Ref: Case no – 313277 Former Tedcastles Yard, Centre Park Road and the Marina, Cork (www.cityparkshd.com)

I refer to the SHD application 313277 that was submitted by Tiznow Property Company Ltd in respect of lands at the former Tedcastles Yard, Centre Park Road and the Marina, Cork City. This application is a proposed development that, if permitted, will allow for the development of 823 residential units (apartments).

SHD-313277 Indicative School Proposal (Dwg No.:0106):

1 SECTION AA
1 : 500

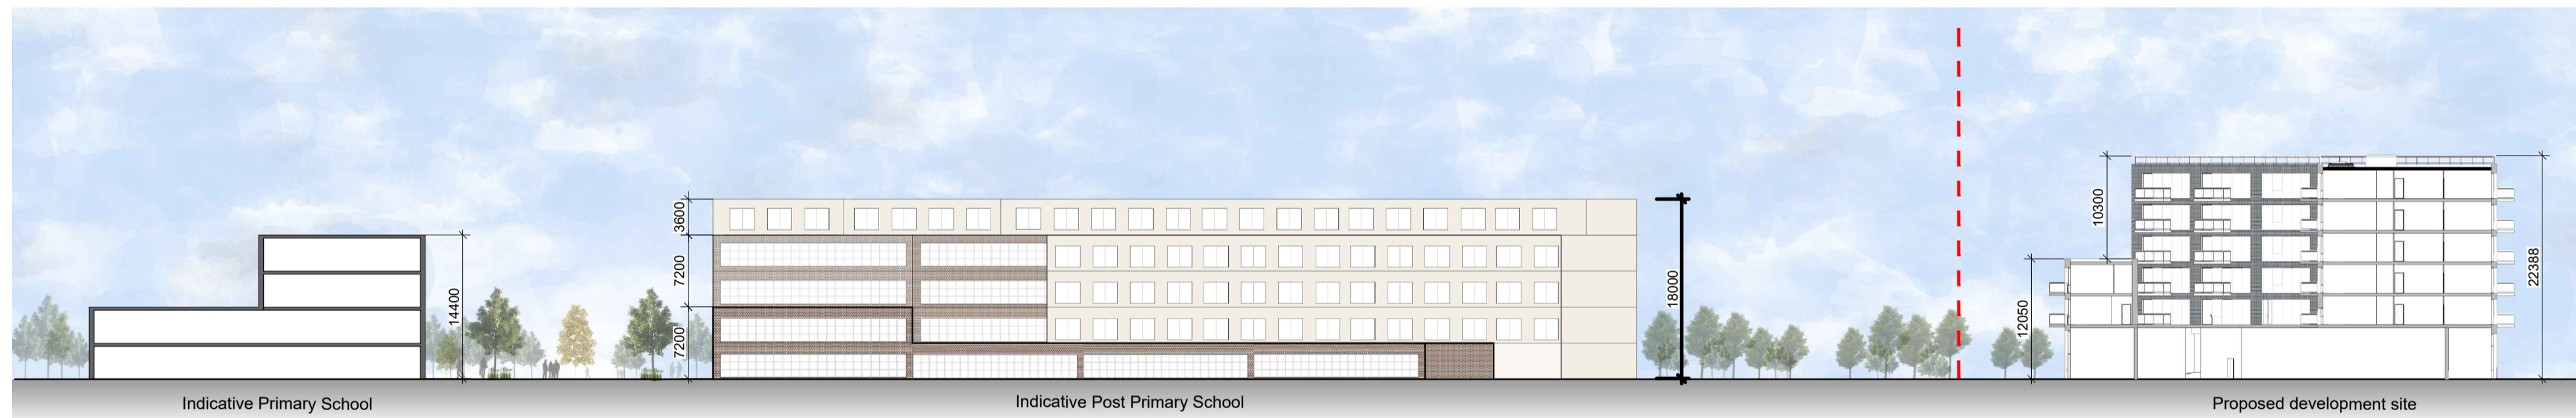
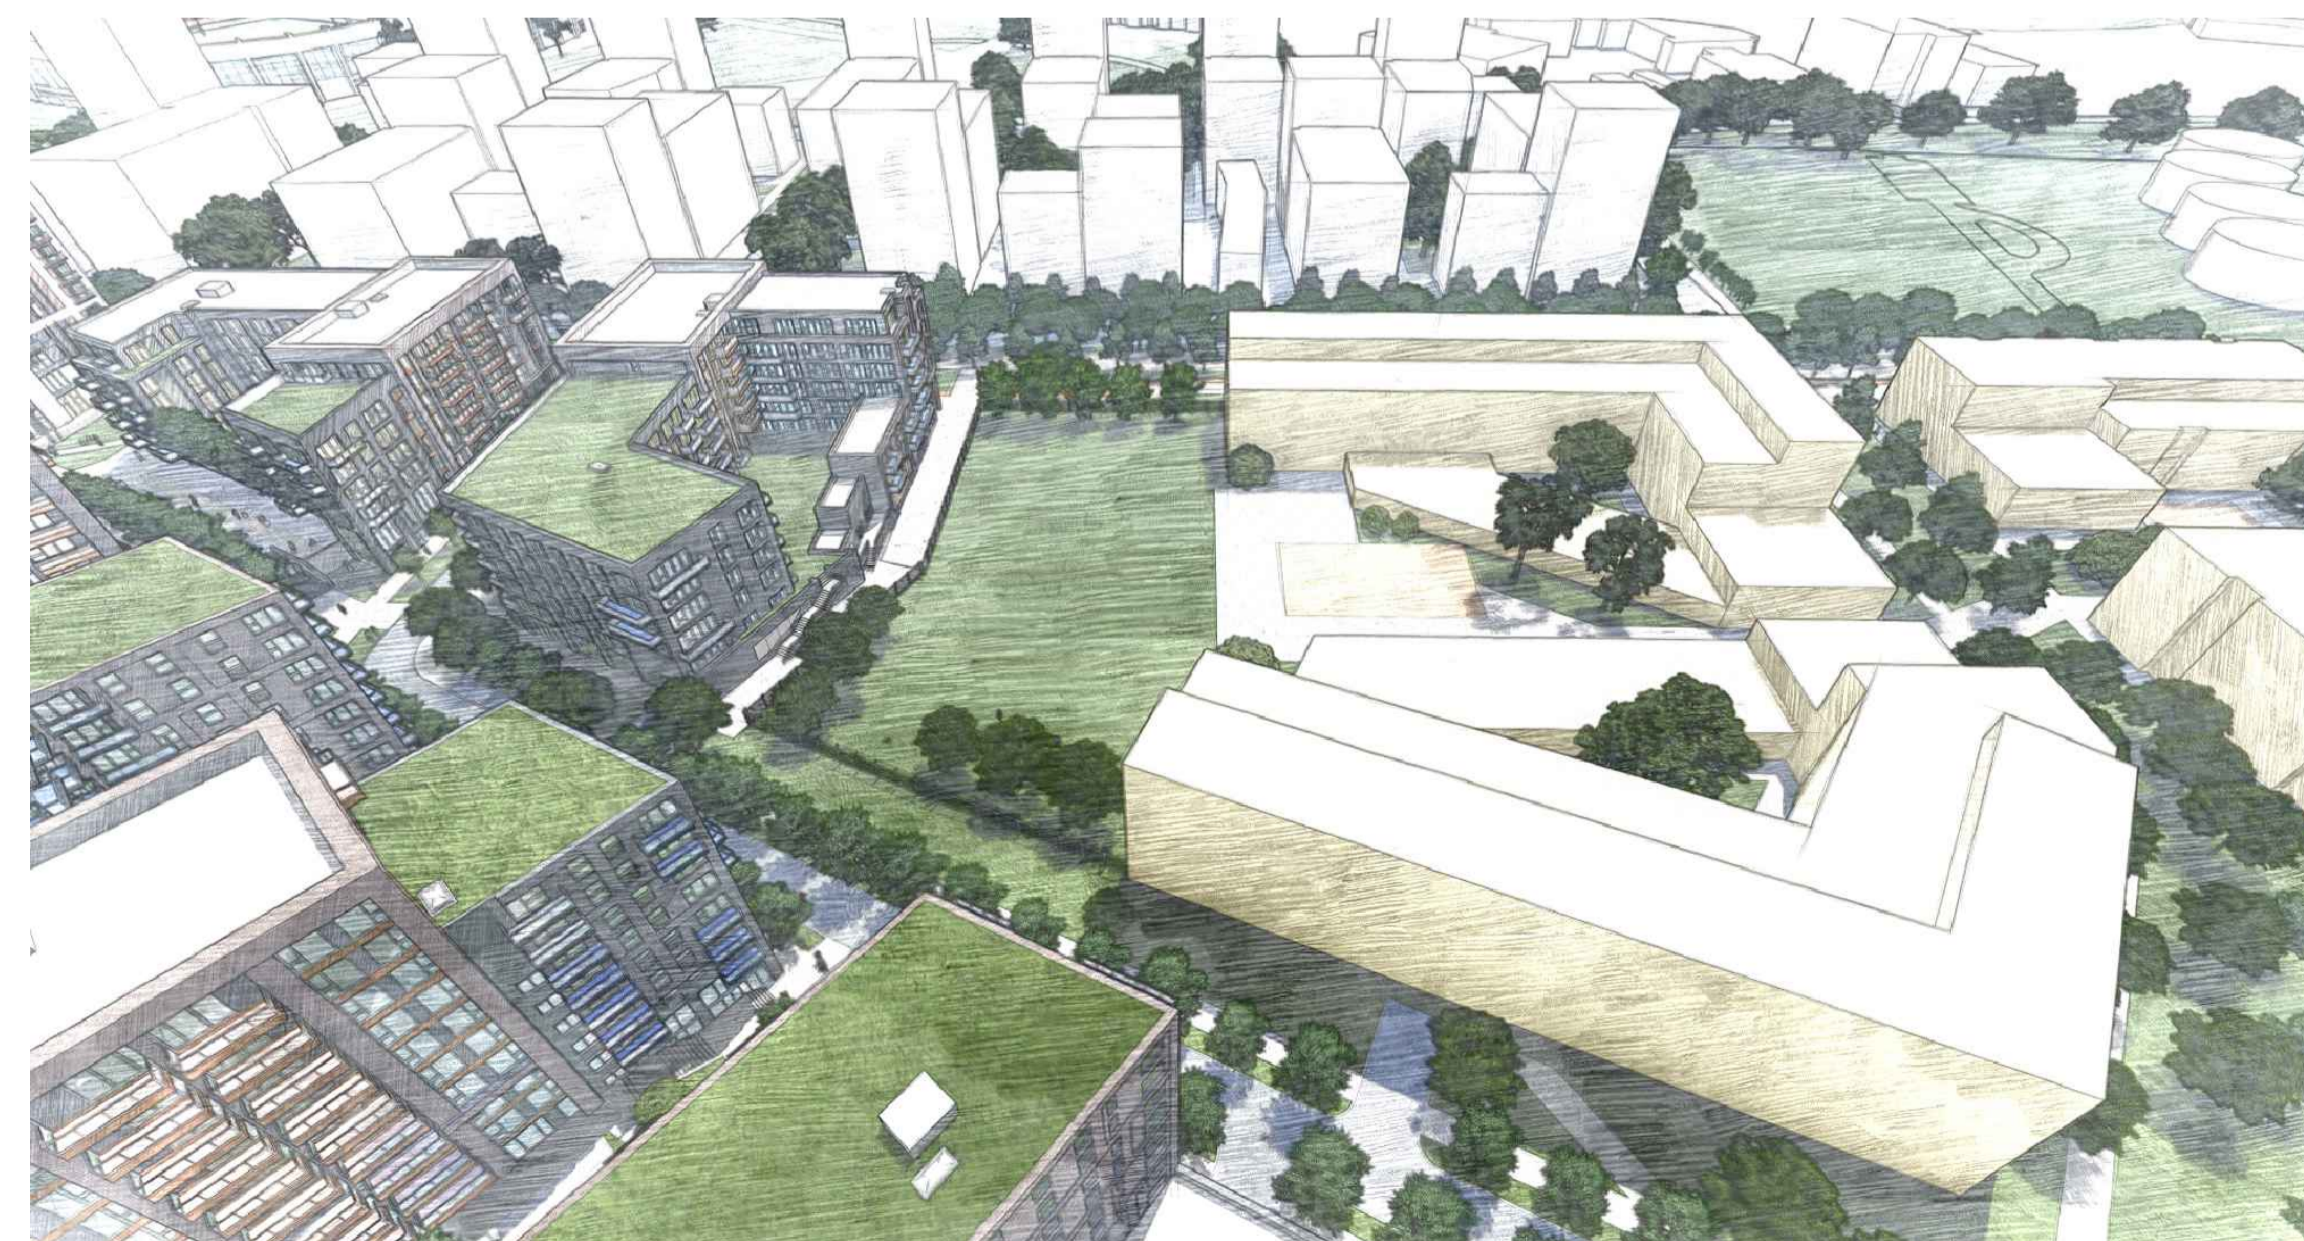
The SHD application contains a drawing titled Indicative School (**Dwg. No.:0106**). It indicates four schools on the schools site, 2 no. primary schools and 2 no post-primary schools, all possibly with special needs accommodation. The applicants proposed school campus is based on inaccurate school sizes and an over-development in both school and pupils numbers. An Bord Pleanála is requested to refer to the Departments drawings contained in this document showing 3 no. school on the school site SHD-313277. The Departments drawings represent the appropriate footprint for 3 no schools at the SHD site. The Department has already indicated that to successfully deliver future school needs in these locations that adjacent public open space, lands and facilities are needed to provide for the numbers of pupils.

Therefore the Applicants proposal is an over-development in schools term. See below.

The Department asks the proactive support of An Bord Pleanála to protect the strategic development of the school site, by conditioning any grant of approval so that the current SHD proposal will not prejudice the future development of the schools site and will, through specific guidance, wording and limits establish an acceptable building line for the schools development no greater than 20m off the nearest point of the SHD building as proposed in this application for an anticipated school building height equivalent to six storeys and an estimated school development height of 26m in height. Any subsequent setting-out errors of the SHD development that might move the buildings closer to the schools will be superseded back to the intended building line in planning.
